SHOALHAVEN CITY COUNCIL

COUNCIL's SUBMISSION to the applicants RESPONSE to SUBMISSIONS REPORT

MAJOR PROJECT APPLICATION CONCEPT PLAN MP09_0088

COUNCIL REFERENCE: 3A10/1003

25405-37

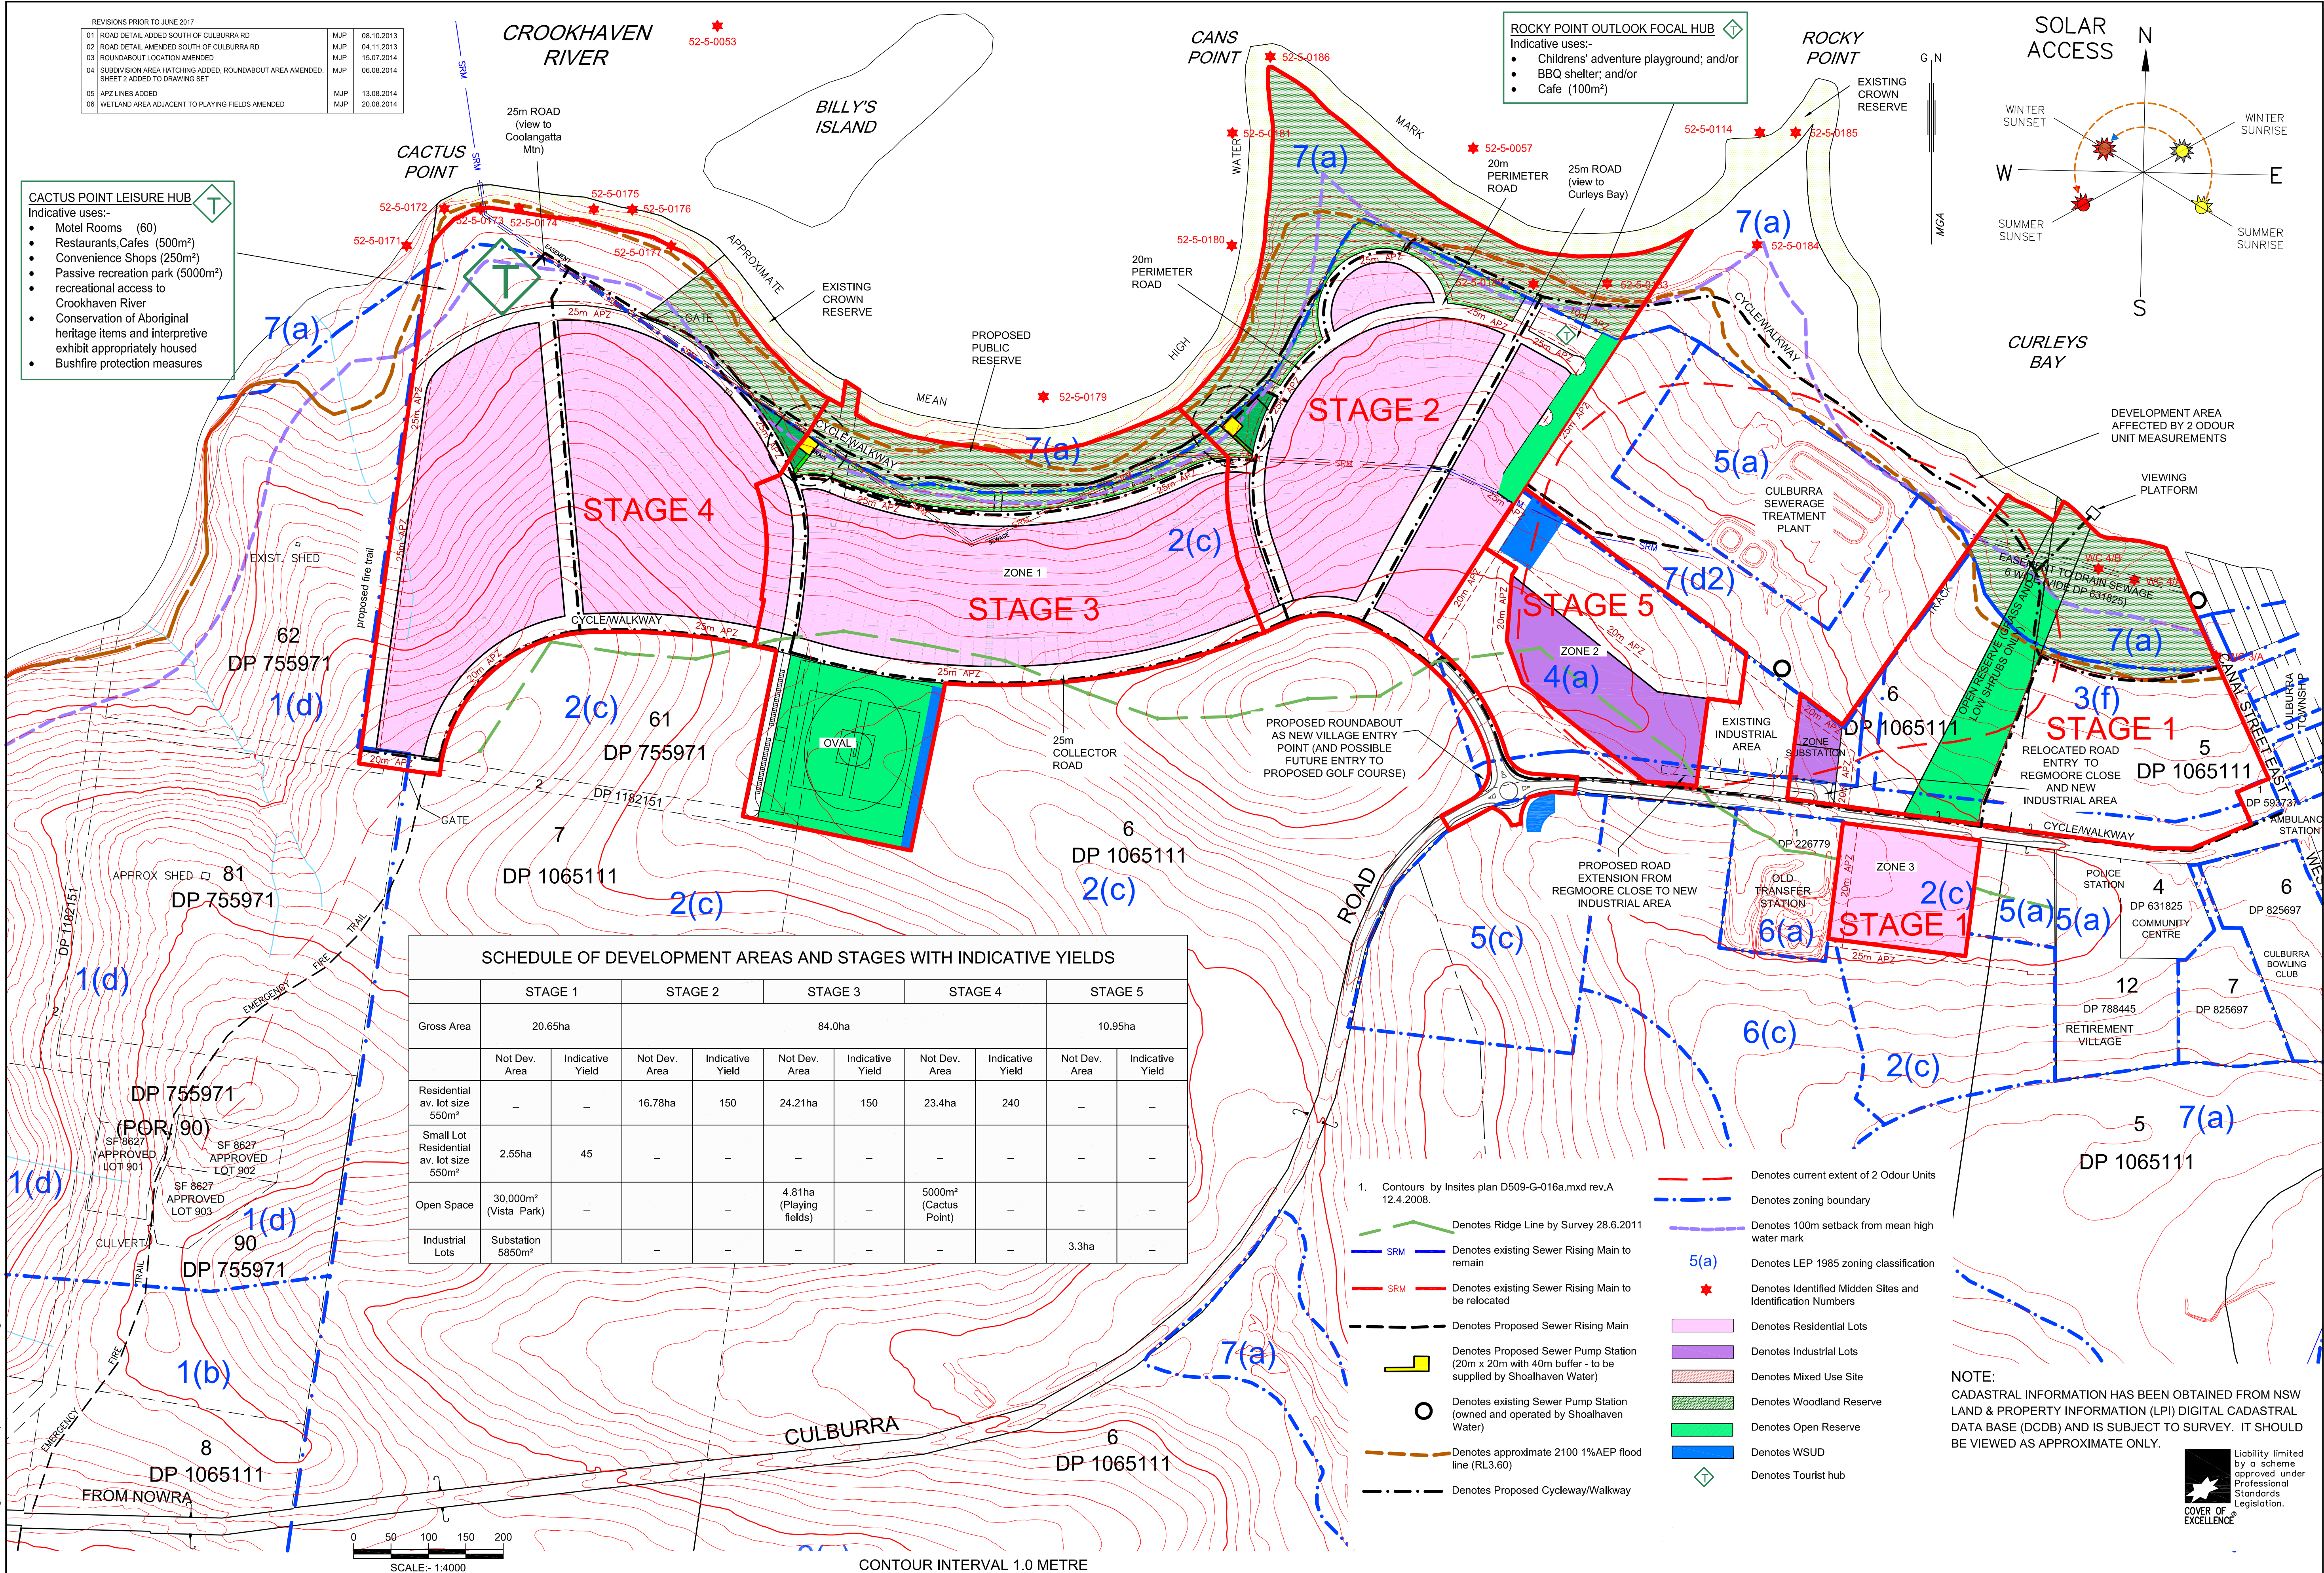
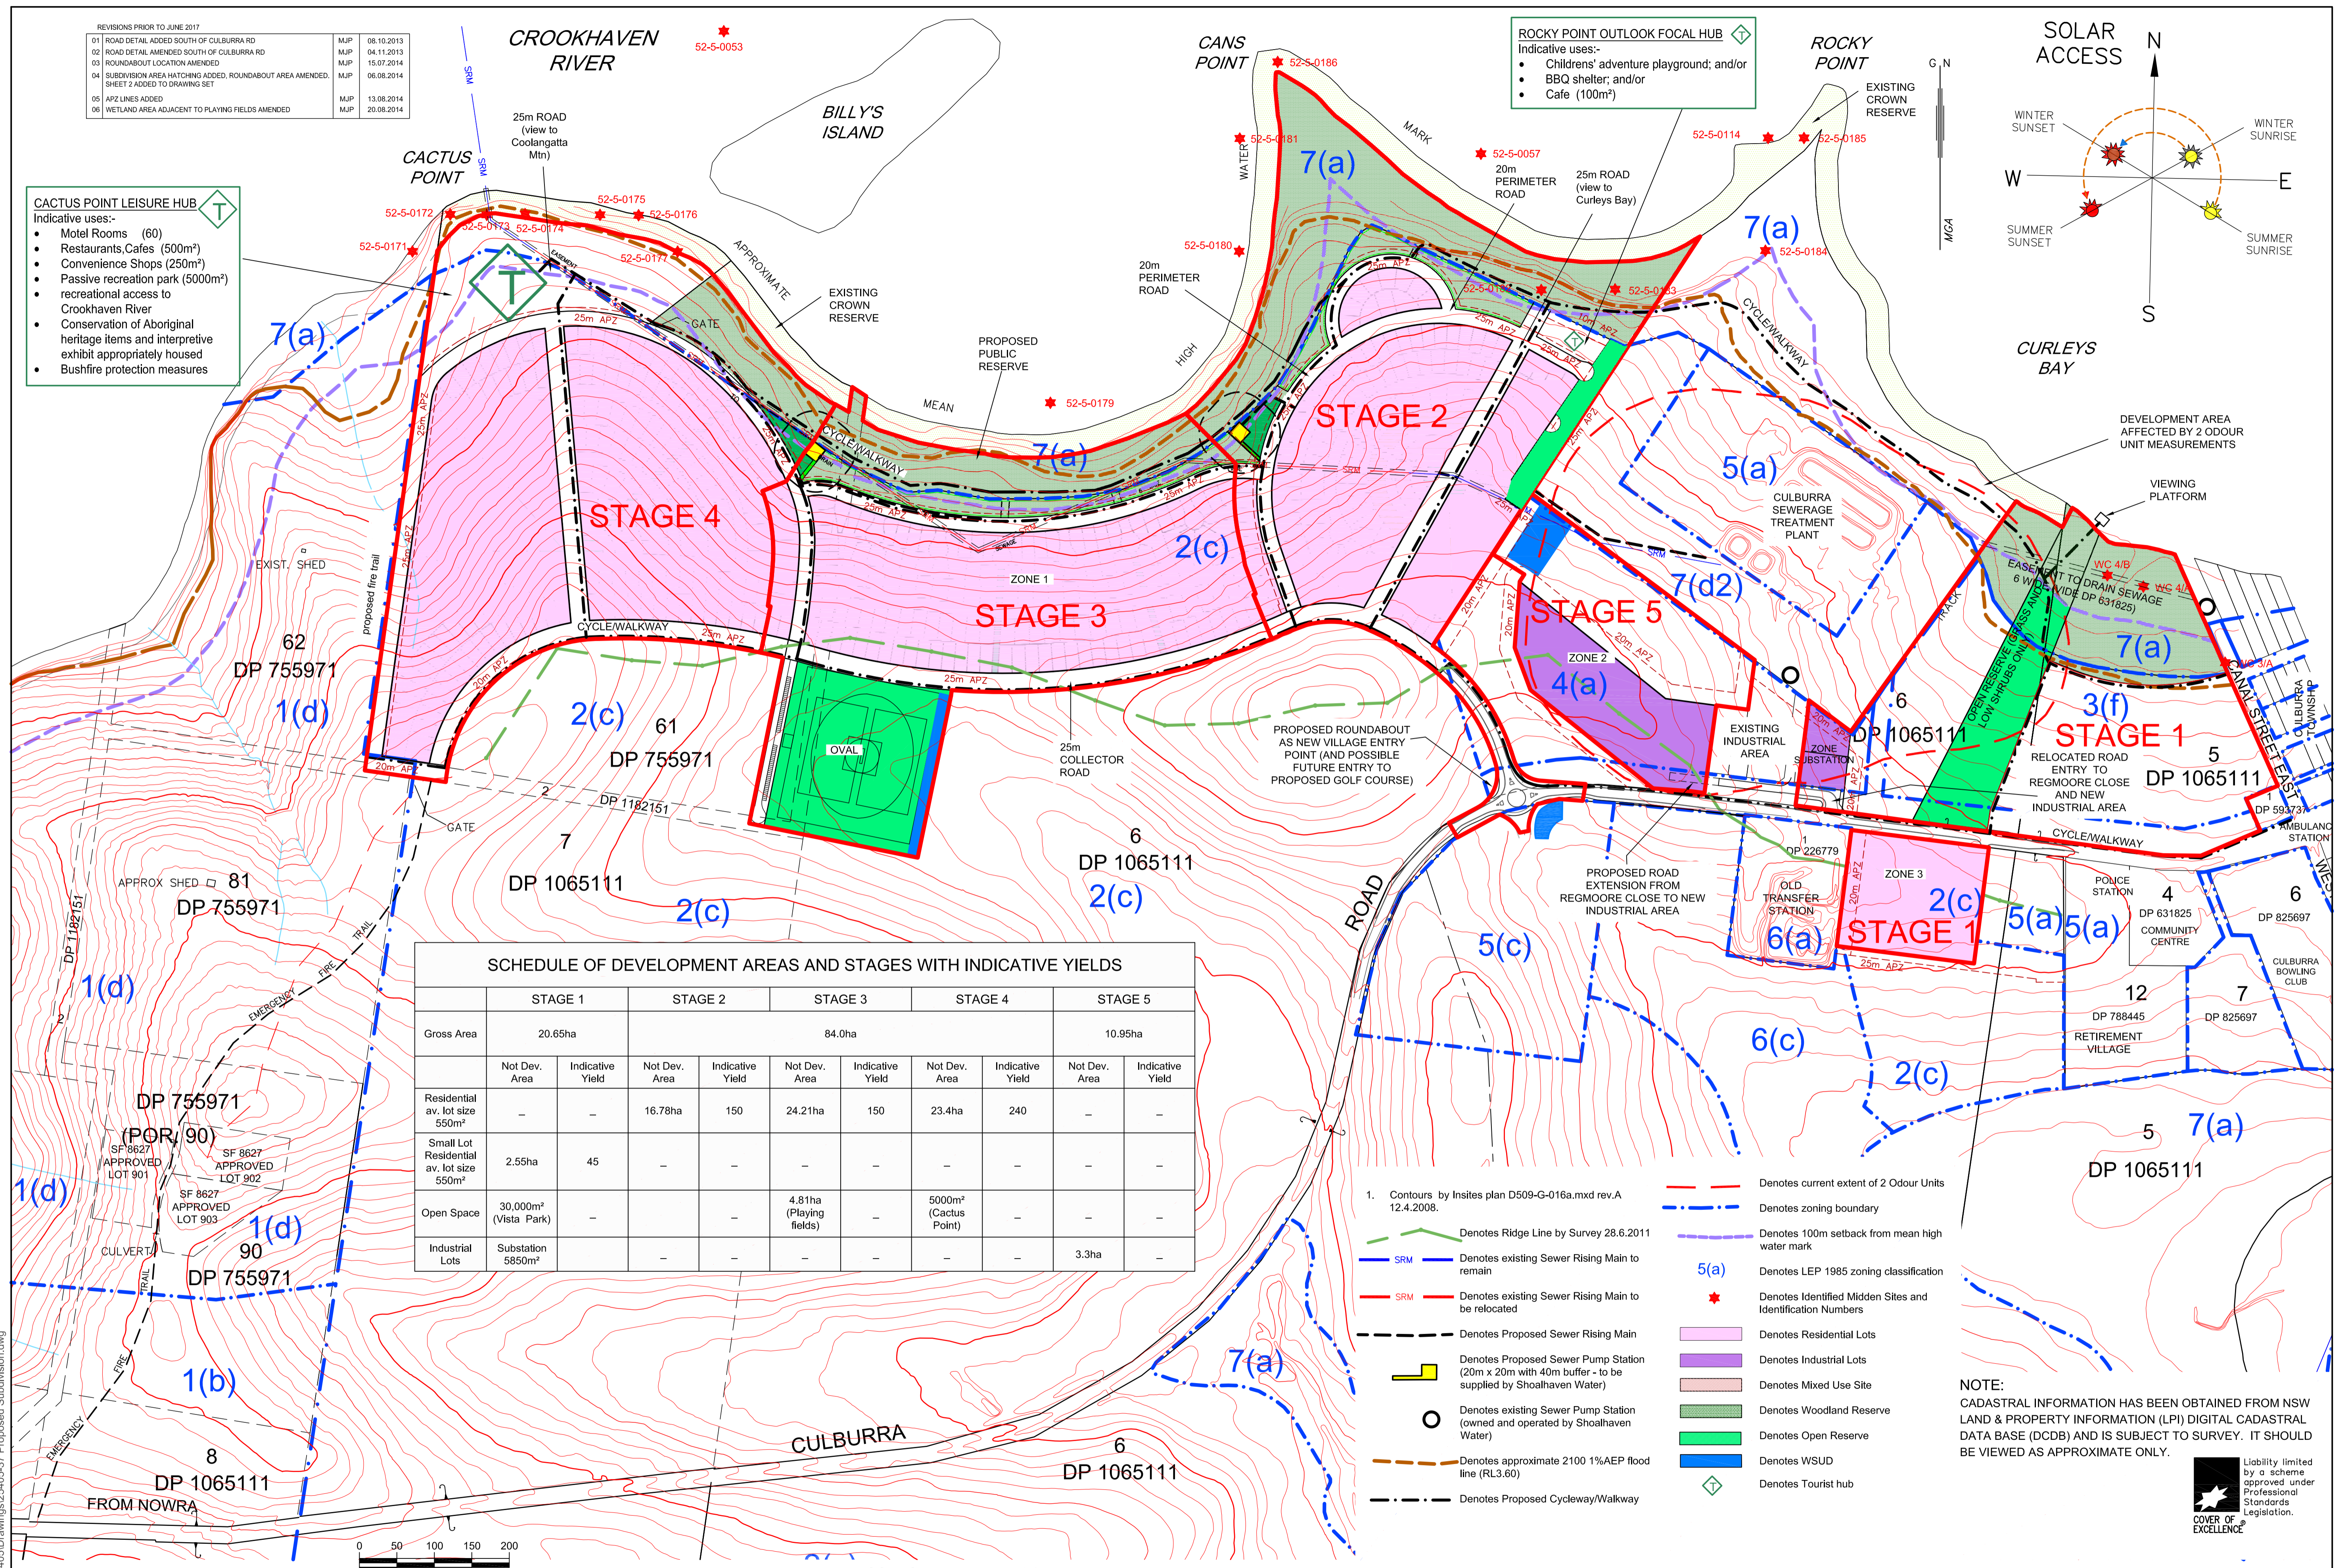
- iv. Amendments are required to the design so as to ensure residential development does not encroach into 7(a) zoned land (see Stage 4 of plan).
- v. In the event of the 7(a) land being rezoned to E2 Environmental Management under draft SLEP 2013, the proponent will need to seek consent if they wish to vary the development proposed within this zone. (referring to paragraph 1 on pp 14 of applicants RTS)

It is noted in the amended layout plan 25405-37 that:

- (a) There are three "viewing platforms" within the waterway and there is limited justification included in the RTS. Such structures could adversely impact the waterway and its vegetation and therefore require further investigation.
- (b) The plan does not indicate what the "blue shaded" areas represent. They appear to be a buffer but are not described. This needs to be included in the legend so it can be commented on and considered by the Department.
- (c) The plan relocates the electricity substation following discussions with the electricity authority and this is acceptable with landscape screening .

- (d) The plan east of the industrial area adds a “hotel site” and “community uses” area without explanation in lieu of the previously termed “future development zone”.

The strategic overlay previously mentioned could put such land use in context, however in absence of this information the previous designation of “future development” should be reinstated to avoid latter assumptions of potential uses.

- (iii) As mentioned before, the “blue” strip between the industrial land and the mixed residential has not been designated. This should be a significant buffer to improve the amenity of the residential development.
